RULE 17 Riverside Energy Park Project – comments on proposed alteration to construction lay down arrangements.

With reference to the changes in the REP application which now envisages use of the proposed data centre site (Cory/Borax fields) as a construction lay down area:

Terrestrial Invertebrate Survey Areas 2018

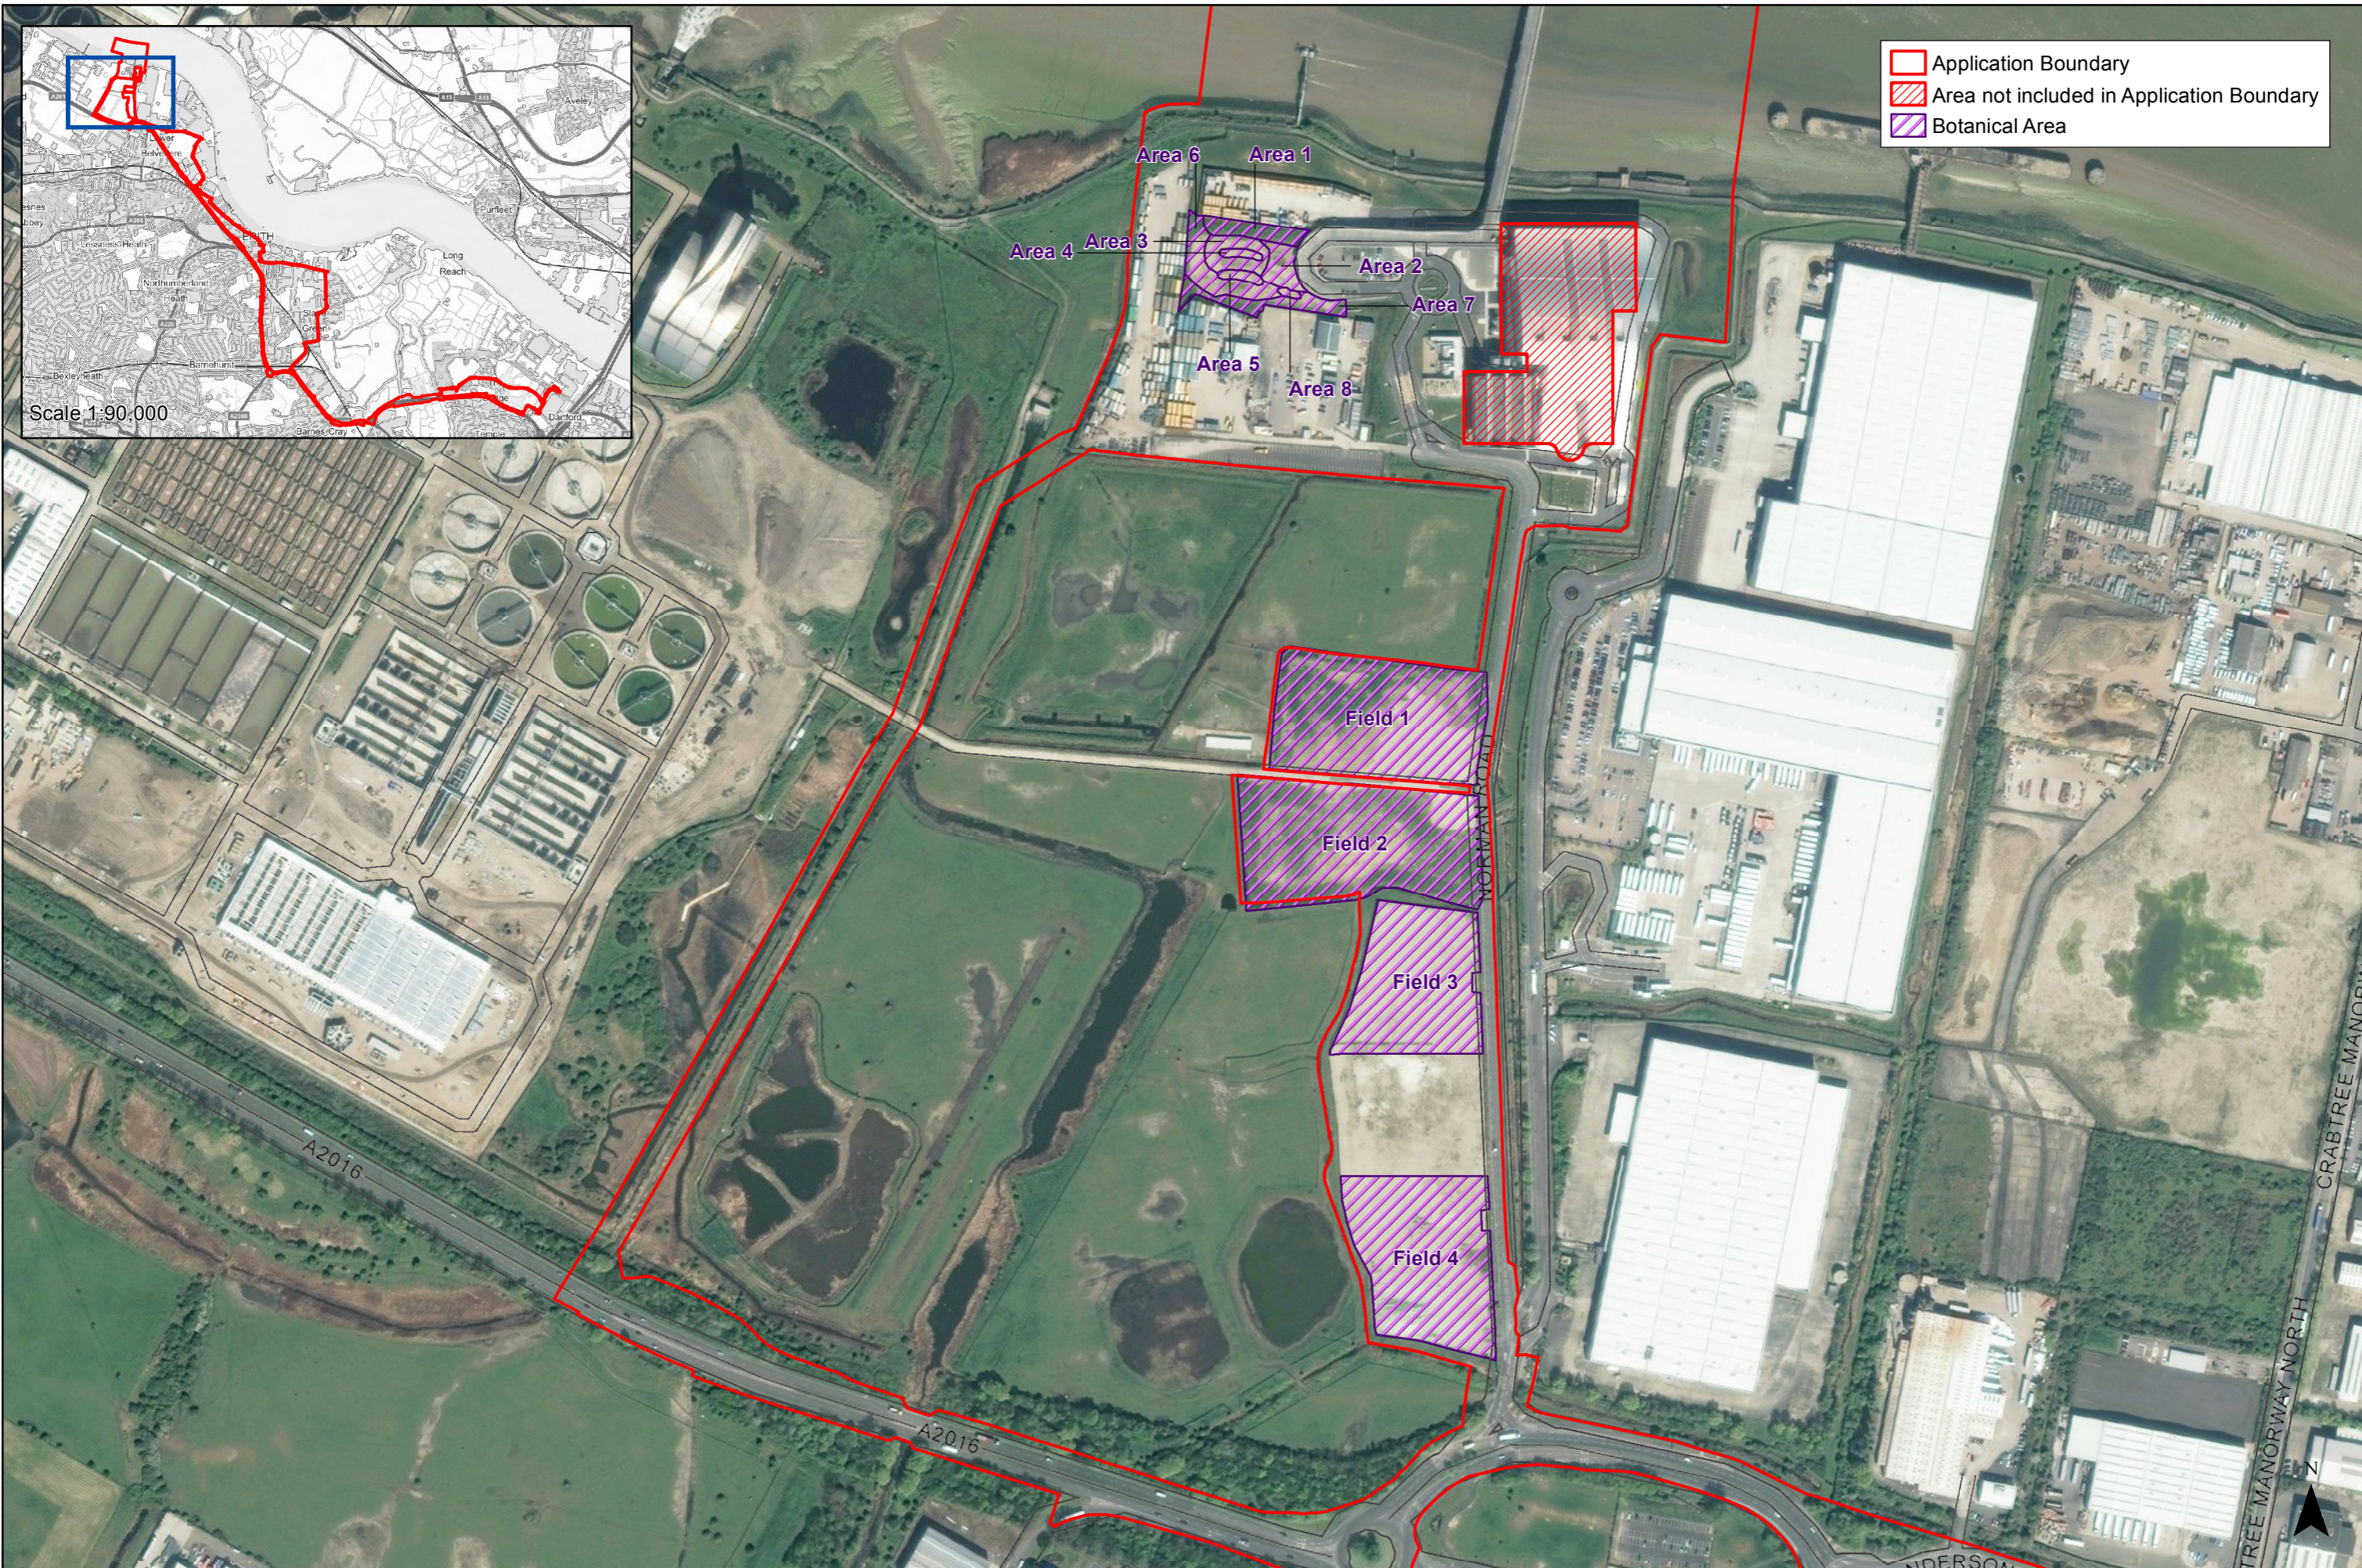
Moreover the report admitted that *'The lack of field work completed in the late summer meant that a number of insect groups that would not ordinarily be expected to present until later in the survey season would have been under represented by the survey. In particular it is considered likely that some species of Aculeate Hymenoptera (ants, bees and wasps) and Hemiptera (true bugs) may be under-recorded.....'*

This means that the presence of the very rare and later-flying Shrill Carder in the immediately adjacent LNR is still not 'officially' acknowledged, and it could occur on the fields.
